23/03428/OUT – OS Parcel 7921 South of Huscote Farm and North West of County Boundary Daventry Road, Banbury

I write on behalf of the Banbury Civic Society.

We wish to object in the strongest possible terms to the development of this site for the construction of up to 140,000 sq m of employment floorspace (use class B8 with ancillary offices and facilities), including earthworks to create development platforms and demolition of the existing farmhouse.

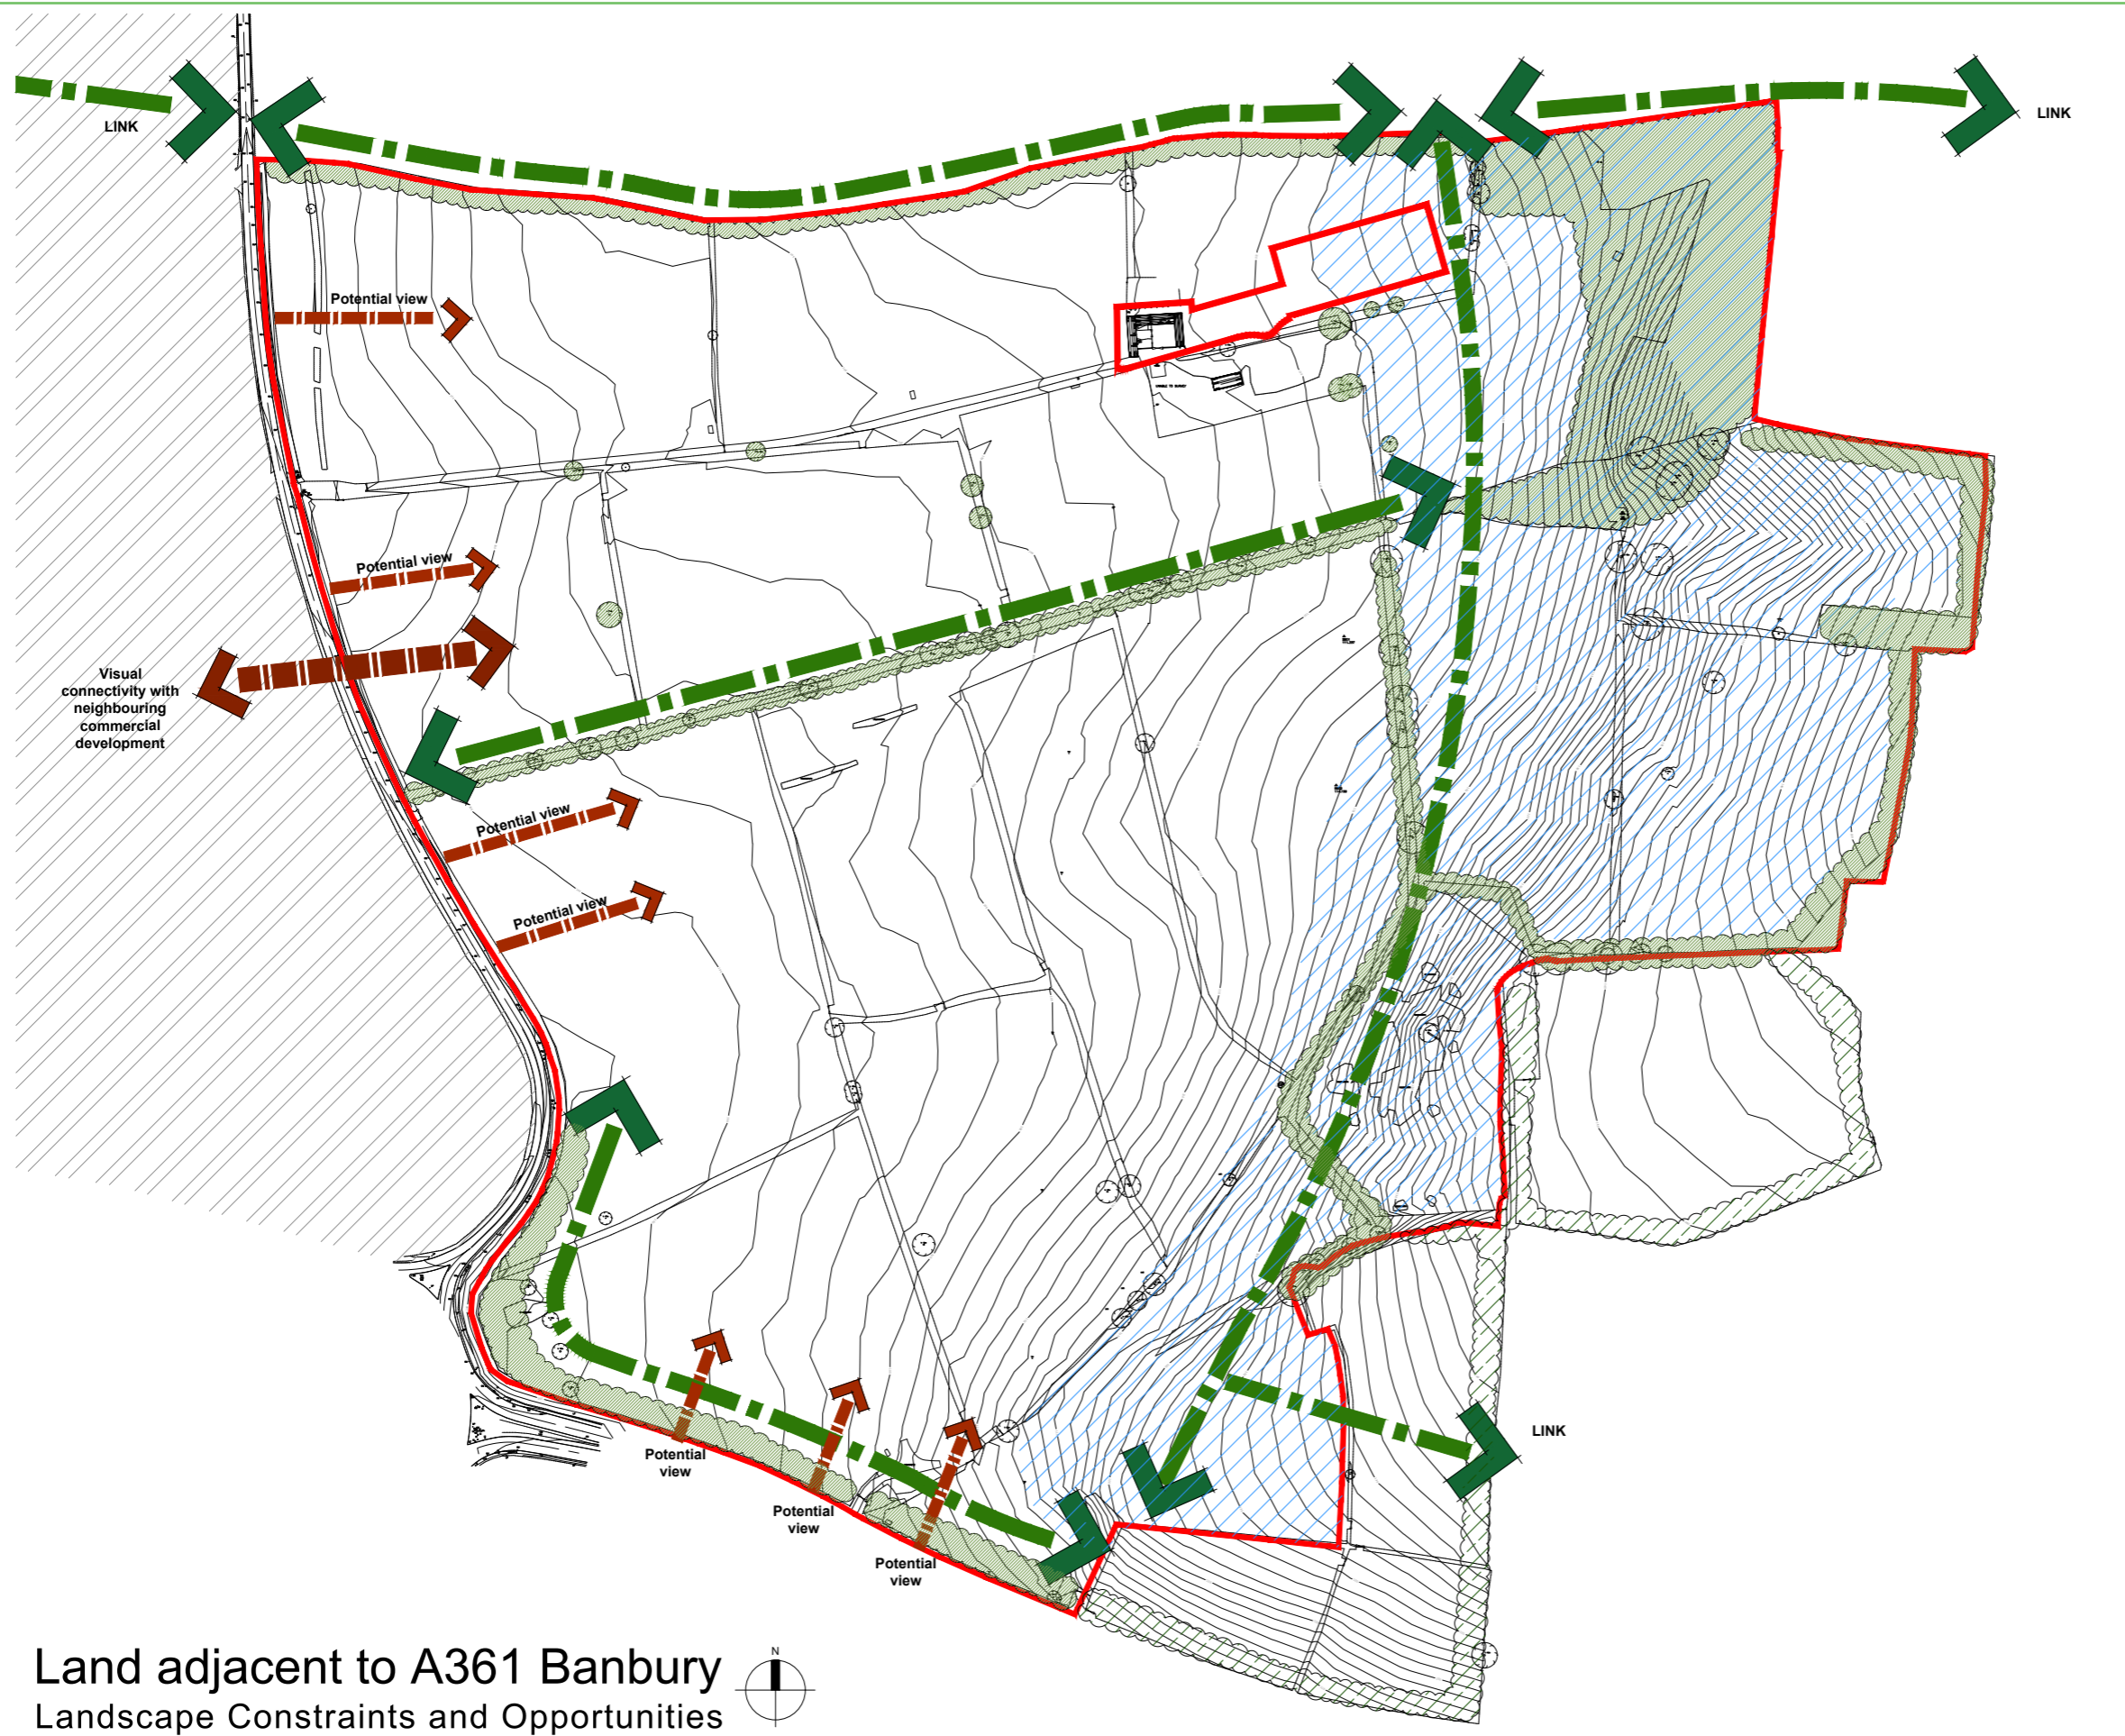
Study Area: To comply with Landscape Institute guidance the study area is woefully insufficient. For buildings up to 23 m high the study area should be 10 km (minimum) from the boundary of the proposals site. In the LVIA chapter the study area is 3km from a point at the centre of this extensive site. Whilst considerably less that the 10km study area advised as necessary in Landscape Institute guidance, it nevertheless shows that the development will be plainly visible from the historic settlements of Overthorpe and Chacombe, from Banbury Crematorium (a location of High visual sensitivity) and widely across swathes of the historic ridge-and-furrow farmlands within the Clay Vales and Upstanding Village Farmlands landscape character areas (Oxfordshire Wildlife and Landscape Study (OWLS)).

Figure 5.4 of the LVIA, showing 3km study area for the Zone of Theoretical Visibility, excluding for example, much of Banbury. Whilst considerably less that the 10km study area advised as necessary in Landscape Institute guidance, it nevertheless shows that the development will be plainly visible from the historic settlements of Overthorpe and Chacombe, from Banbury Crematorium (a location of High visual sensitivity) and widely across swathes of the historic ridge-and-furrow farmlands within the Clay Vales and Upstanding Village Farmlands landscape character areas (Oxfordshire Wildlife and Landscape Study (OWLS)).

Appendix 2: Figures

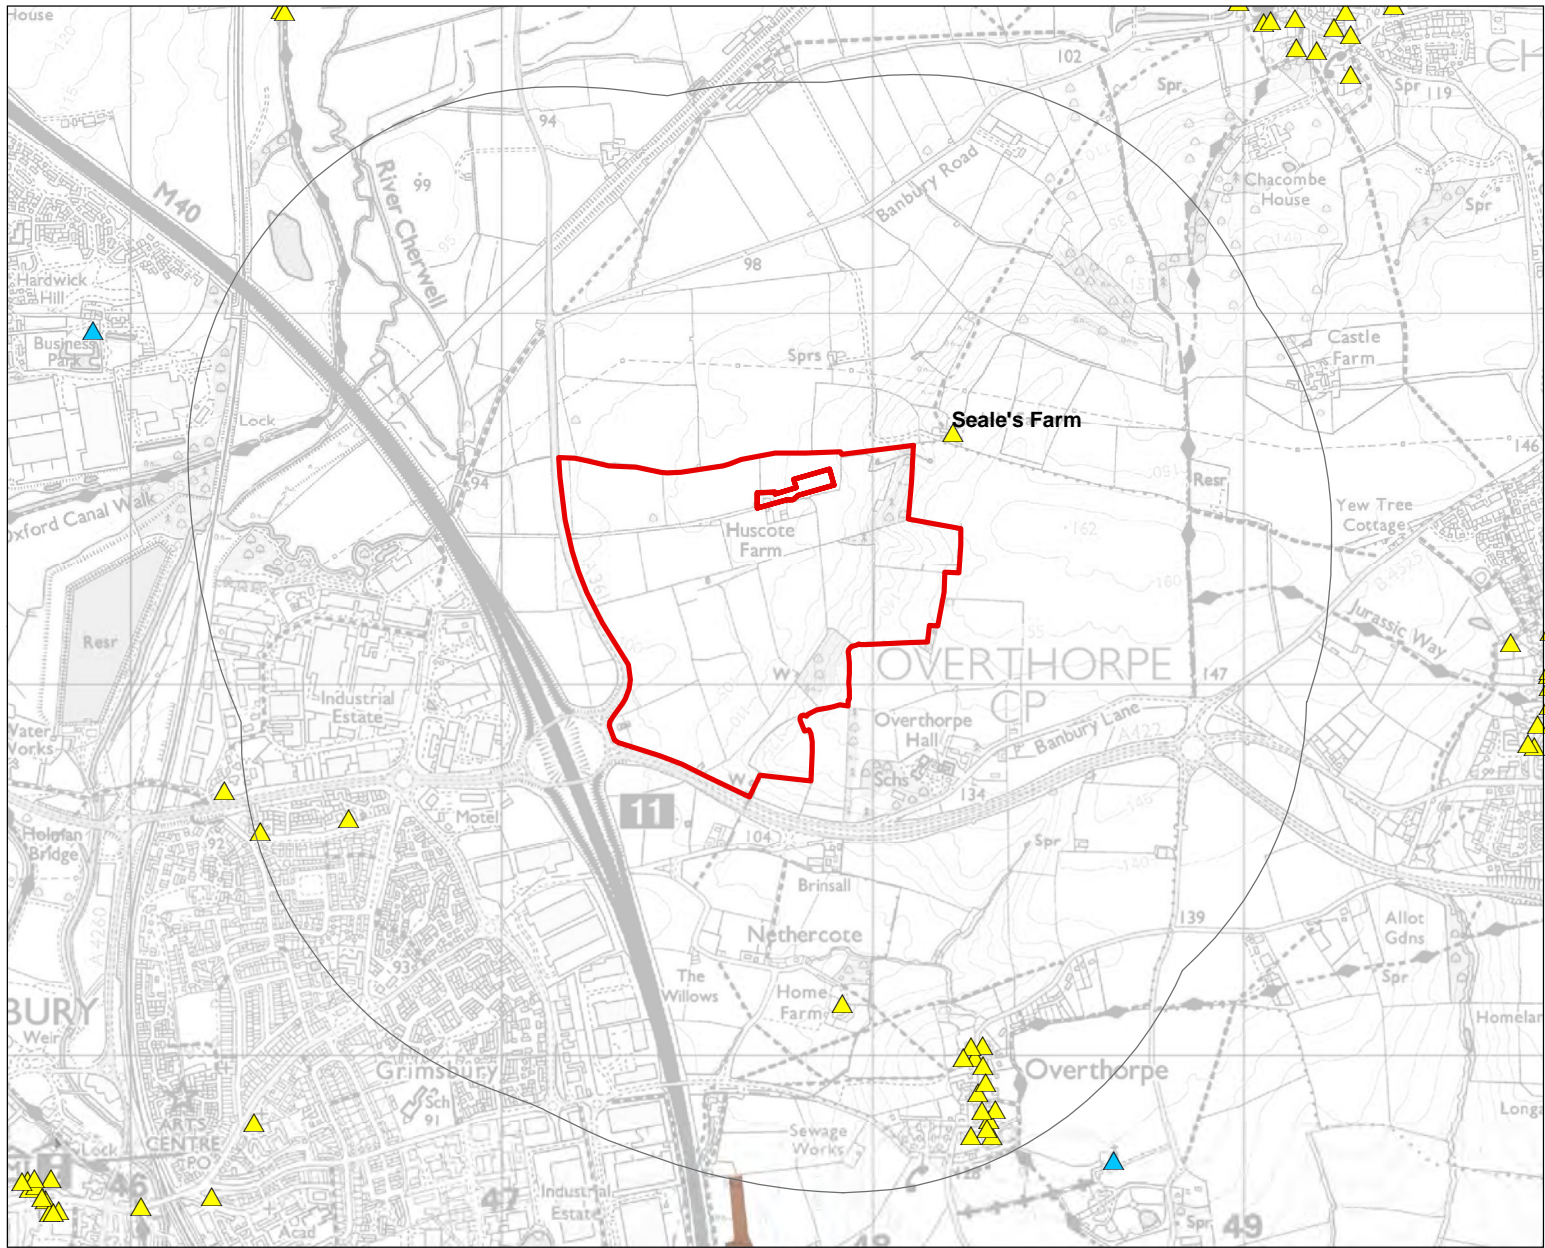
Despite the extensive (but non-compliant) 3km ZTV assessed in the LVIA (see above), the Heritage Desk-Based Assessment adopts a study area of only 1km from the boundary of the proposals site (Appendix 2, Figure 1 of the DBA, below). Despite the obvious limitation of such a constrained study area, given the ZTV and visual prominence of the proposals site, this study area includes the Grade II Home Farm, Nethercote, the Grade II Seale's Farmhouse and 13 Grade II Listed buildings in Overthorpe. Because of the limited radius, the study area misses some 30 Grade II Listed buildings in Chacombe, including the Grade II* Chacombe Priory and Grade I church.

The 1km study area includes parts of the Overthorpe Conservation Area and the Oxford Canal Conservation Area. Despite this, neither conservation area is acknowledged in the Desk-Based Assessment or the Heritage chapter, so the impacts and effects of the proposed development on both are not assessed. Because Chacombe Conservation area and its listed buildings lie just outside of the 1km study area, any impacts and effects on these are also not assessed, despite their proximity to the proposals site and their inclusion within the ZTV of the proposed development.

Heritage assets plan from Appendix 2, Figure 1 of the applicant's Desk Based Assessment (ES Appendix 6.1), purporting to show Designated Heritage Assets within 1km of the proposals site
